Application for Householder Planning Permission

Development Convert existing garage and walkway to a bedroom and bathroom, extend existing pitched roof over both areas replacing the flat roof. Extend front of garage to the front of the bungalow.

Location 38 Winston Crescent Bersted

Proposed Elevations

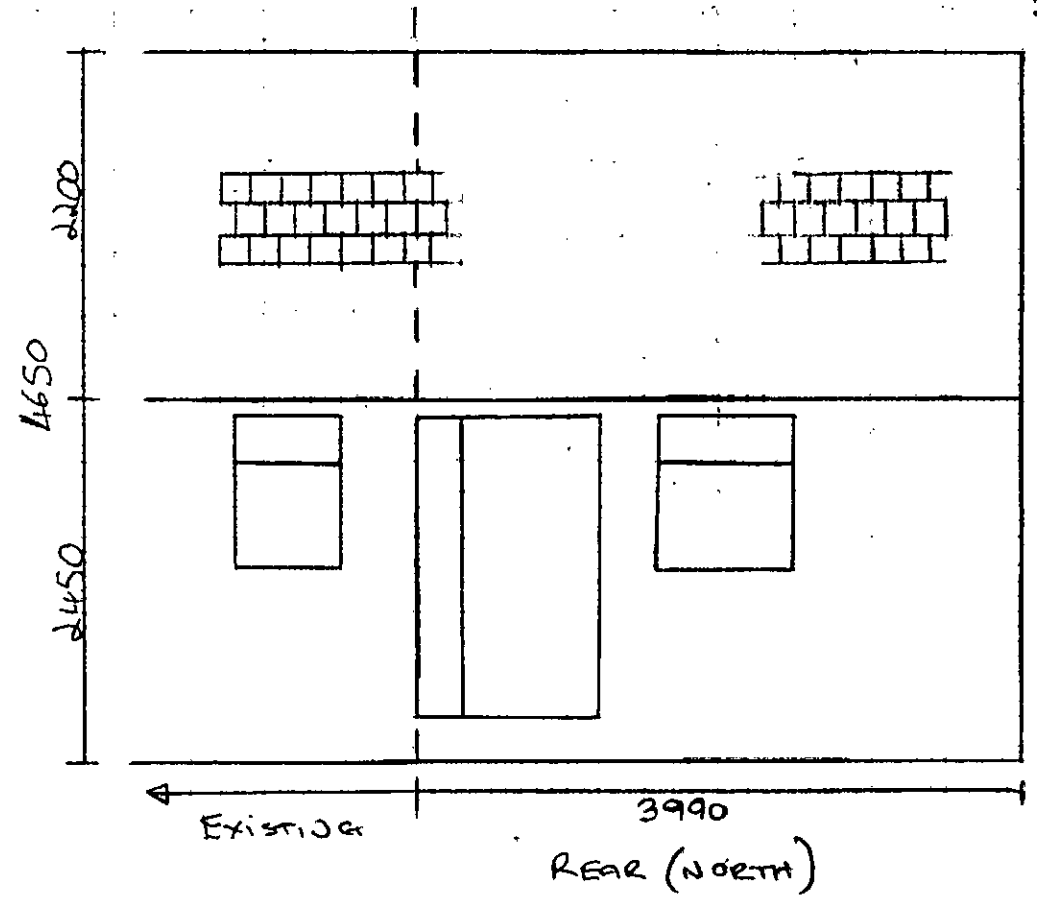
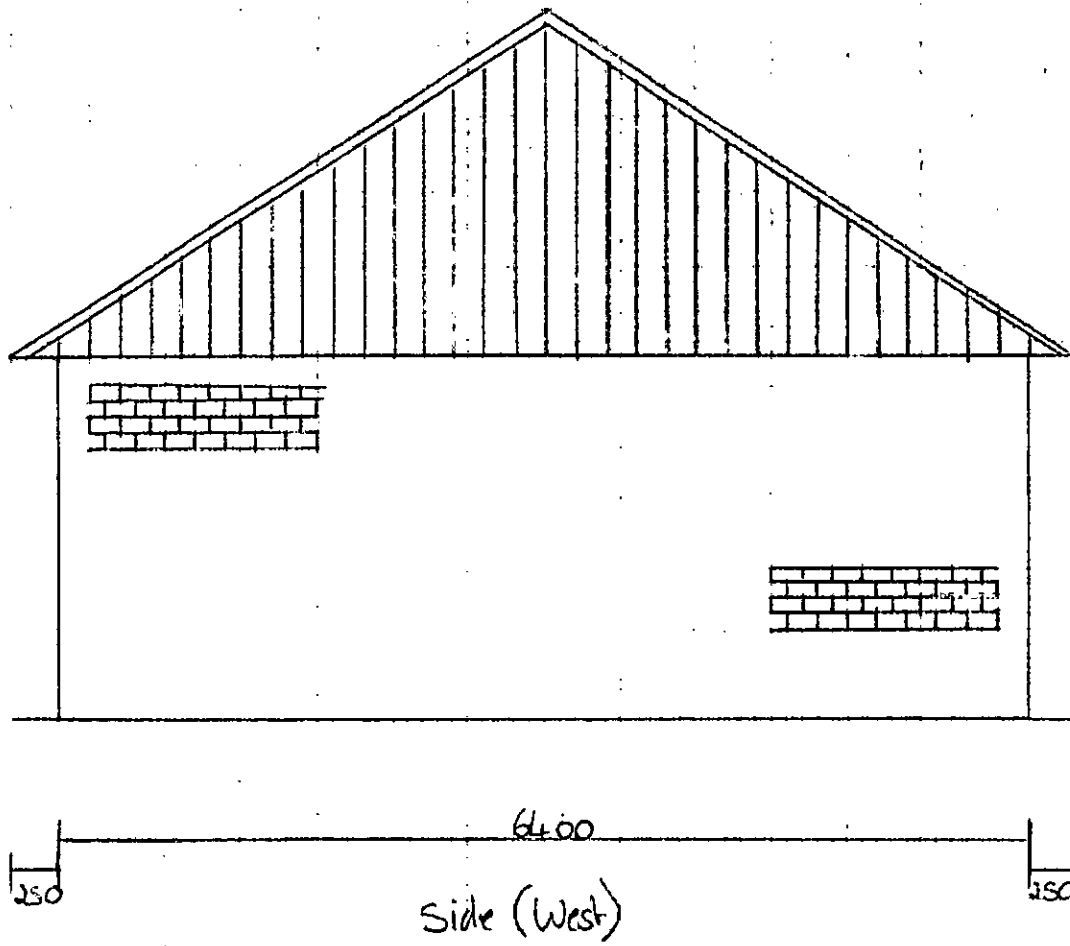
The North elevation and floor plan do not accord. The toilet window is missing and the door and new bathroom window do not measure correctly. Please forward amended plans accordingly
